Application No.	2021/91270
Proposed Development:	Change of use from dwelling (C3) to offices (Class E)
Location:	30, Leeds Road, Dewsbury, WF12 7BG
OS Map Reference	SE 424902.2121 421926.0569
Applicant/Agent:	Martin Walsh Architectural
Class:	Other Developments

**Consultation Response from KC,
Highways Development Management**
2021/91270 30, Leeds Road, Dewsbury, WF12 7BG
Change of use from dwelling (C3) to offices (Class E)
Date Responded: 08/09/21 Responding Officer: CNB Responding Ref: K15-2NE/43

LOCATION PLAN SHOWING OWNERSHIP

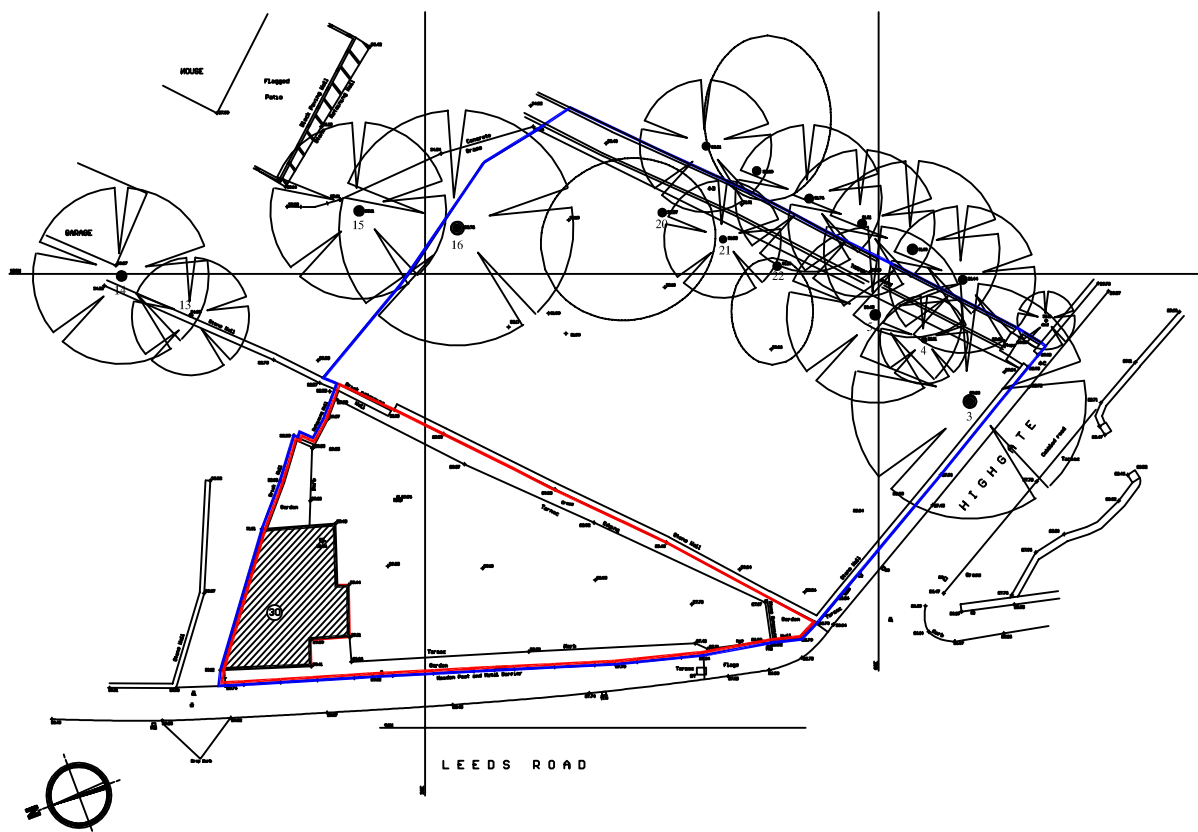
The application form proposes that 4 car parking spaces will be retained within the existing car park, however no details were provided and so we would like to see the parking spaces shown clearly on a drawing with sufficient manoeuvring space to allow vehicles to enter and exit the site in forward gear for highway safety reasons as the highway adjacent to the access is a classified A-road. This may require a swept path analysis. The manoeuvring area should be clearly marked on a drawing so that it can be protected through planning. This should be conditioned.

No waste storage and collection details were provided with the application, however we suspect that waste collection will be carried out as present. We would like to see the location of waste storage and a collection presentation point clearly indicated on a drawing in such locations that they are accessible to a cleansing operative but do not cause an obstruction of the parking or turning spaces or the adopted highway or footway for road safety reasons. This should be conditioned.

Notwithstanding the details shown on the approved plan, no development shall take place until a scheme detailing arrangements and specification for layout of parking and turning have been submitted to and approved in writing by the Local Planning Authority. Before any building is occupied the development shall be completed in accordance with the details shown on the approved plans and retained thereafter.

Before development commences, details of suitable storage, bin presentation points and access for collection of wastes from the premises hereby approved shall be submitted to and approved in writing by the Local Planning Authority. The approved details shall be provided before first occupation and shall be so retained thereafter.
